**A122 LOWER THAMES CROSSING (REF: TR010032)
DEADLINE 6 WRITTEN REPRESENTATIONS**

MELVILLE HAMILTON LOWE MOTT – AFFECTED PARTY REFERENCE: AP1308

C H L MOTT & M MOTT – AFFECTED PARTY REFERENCE: AP1369

On behalf of our above clients, the Mott family, we write further to Compulsory Acquisition Hearing 3 ('CAH3') held on 17 October 2023 with our written submissions in support of the oral representations made at that hearing.

Plate 19

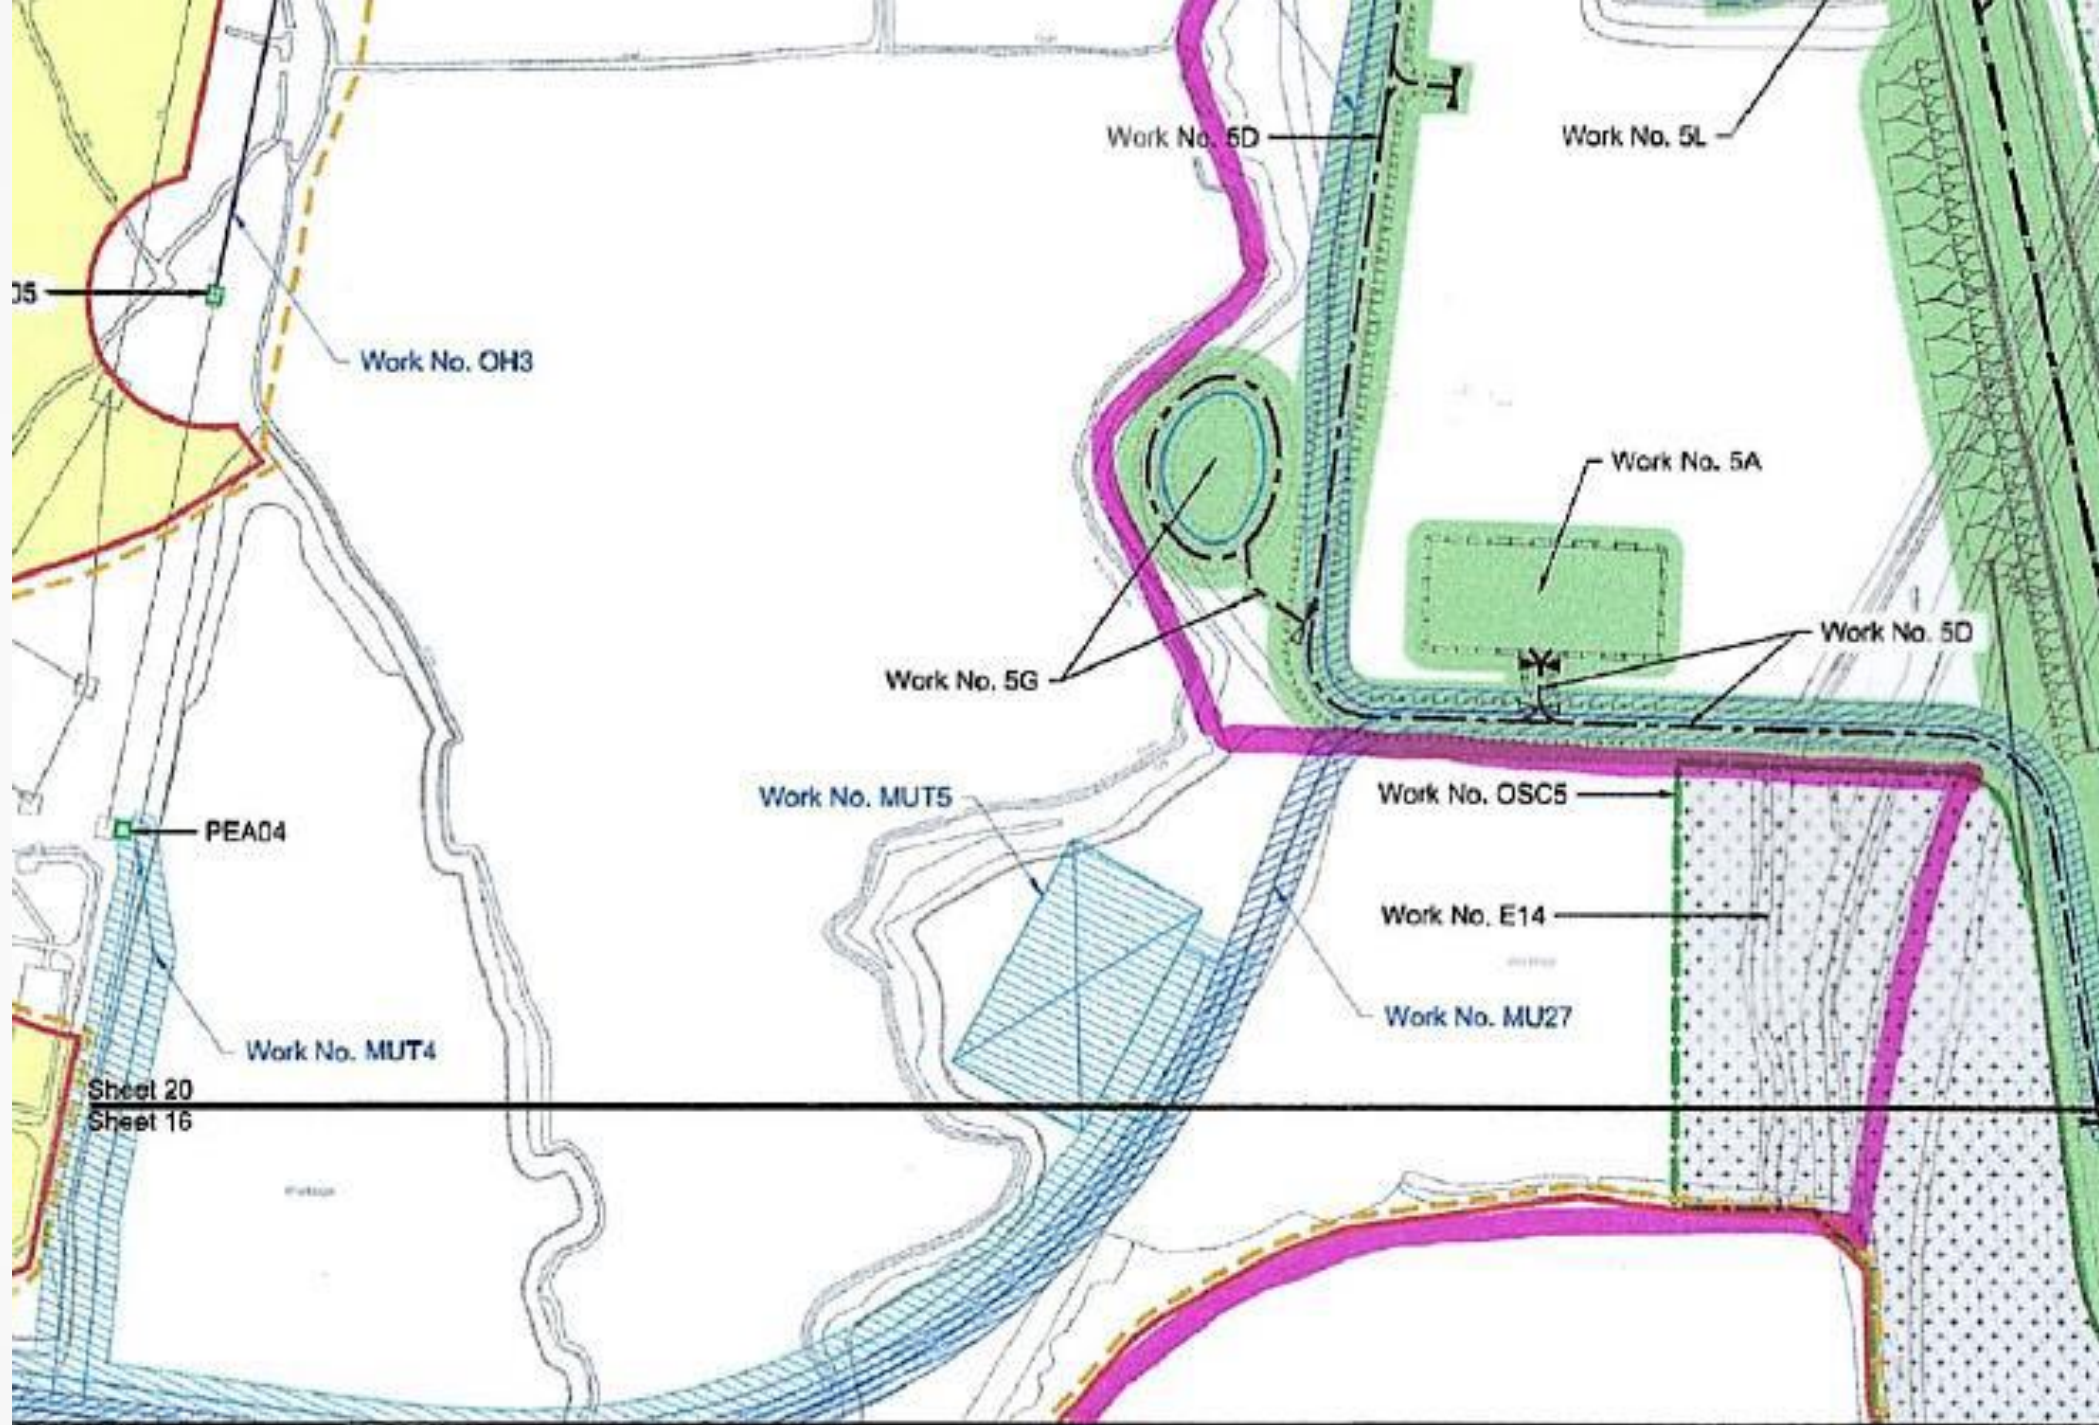
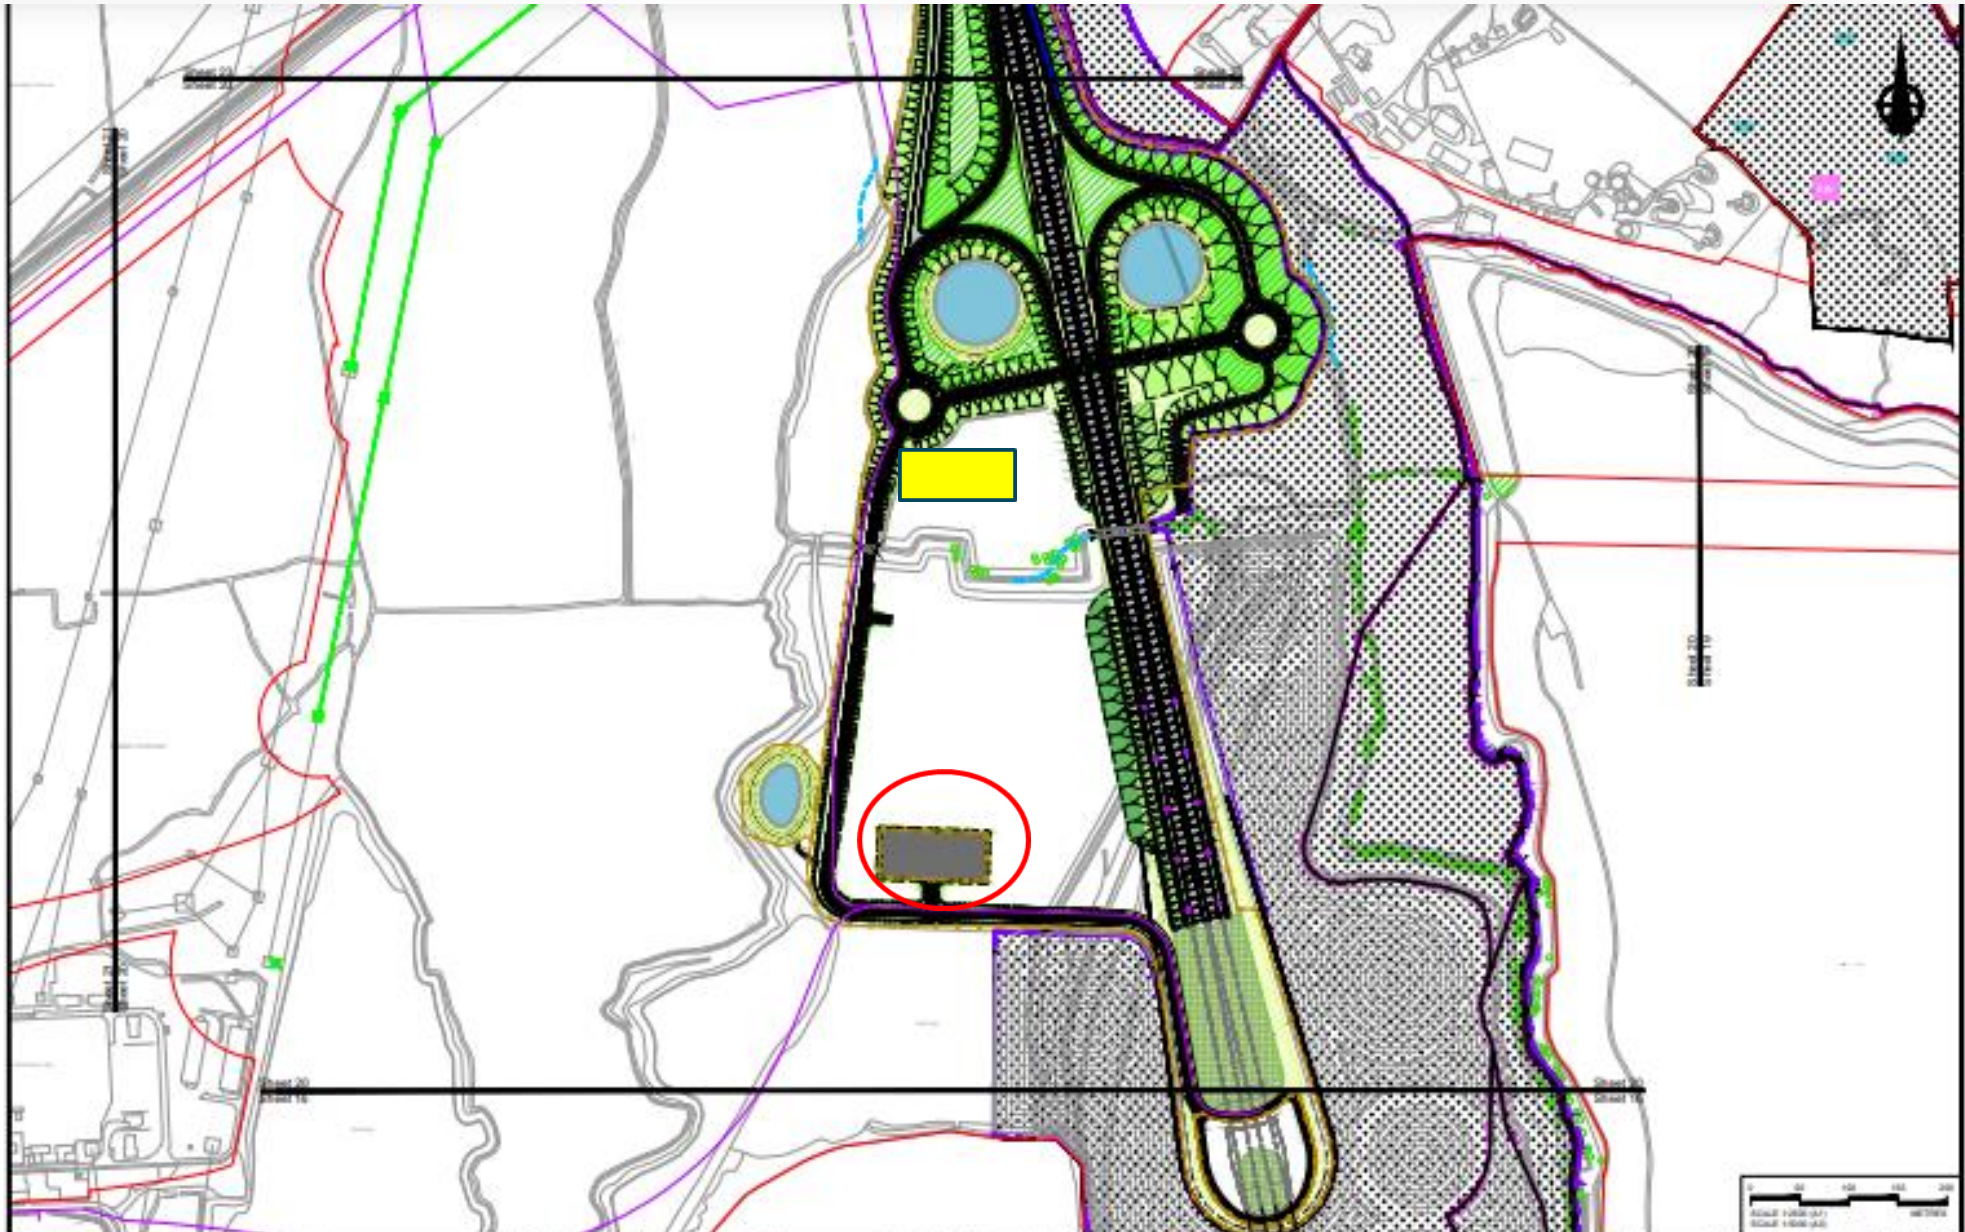
<p>Emergency Vehicle RVP</p>	<p>Plates 19, 20, 21 show the Applicant's proposed and our client's proposed alternative location of the RVP.</p> <p>Our submission is as follows:</p> <p>A technical working group should be formed between our client, the Applicant and the Emergency Services and Safety Partners Steering Group (ESSPSG) to agree mutually acceptable location for the RVP; to include</p>

# Plate 24

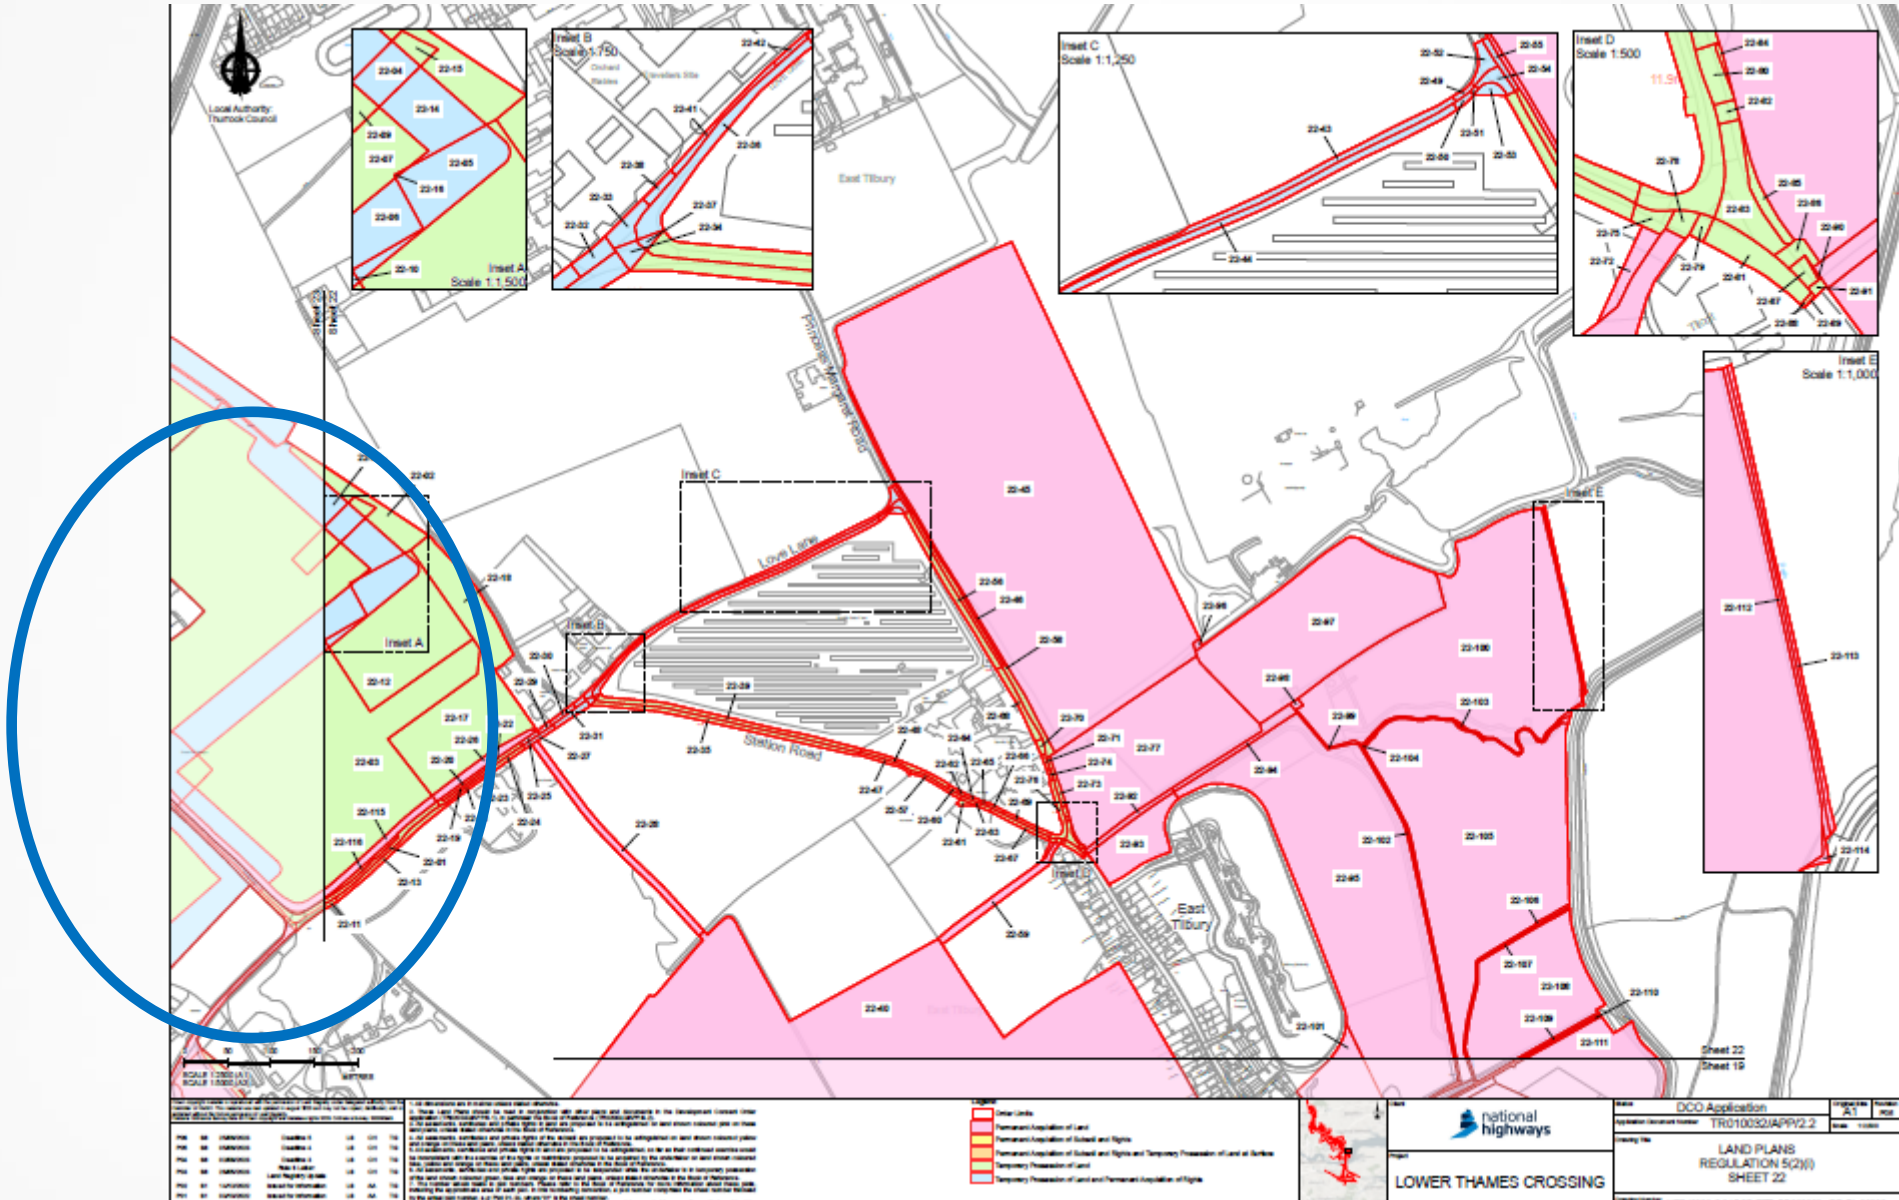
agreement on the specification of construction and access off the Northern Portal Access Track.
Linford Borehole & Water Pipeline	<p>Plates 23 & 24 show the route of the proposed temporary water pipeline coloured blue as temporary possession with permanent rights.</p> <p>We refer you to the Deadline 2- Applicants Response to IP comments on draft DCO at Deadline 1 REP2-077 which stated:</p> <p><i>5.7.3 The Applicant has, in limited circumstances, sought rights and restrictive covenants to enable statutory undertakers to have adequate land and rights in connection with temporary assets. The Applicant is aware there are concerns from affected landowners regarding those rights sought for temporary utility works that would enable the construction of the Project (Work Nos OHT1–OHT8 and MUT1–MUT32) and is considering its options and available mechanisms from which to provide comfort to landowners that these rights will be extinguished at the earliest opportunity unless otherwise agreed with the landowner.</i></p> <p><i>5.7.4 In relation to the proposed Linford water pipeline (Work No. MUT6) plot numbers 23-121, 23-139, 23-153 are listed in Schedule 8 of the draft DCO [REP1-042] which sets out the requirements for land within the Order Limits. Permanent rights are required for the installation and operation of the temporary water pipeline, which would be removed following construction.</i></p> <p>Our submissions are as follows:</p> <ol style="list-style-type: none"> 1) In our opinion, there continues to be no justification for permanent rights for a temporary water pipeline and our client objects to any permanent rights which result in the statutory undertaker seeking continued use beyond use by the Applicant for the purposes of the Project. 2) With reference to the Applicant’s state position (as set out above) in respect of removal of the pipe, a technical working group with Applicant, contractors, our client and Mulberry Strategic Land Ltd should be formed to agree the best approach to decommissioning the pipeline together with a SACR commitment that the pipeline will be removed on cessation of use or a removal commitment should the pipeline prevent any future development of the land area in which the pipeline is constructed and with the full cost of that removal and all associated remedial works being met in full by the Applicant’s or relevant statutory undertakers.
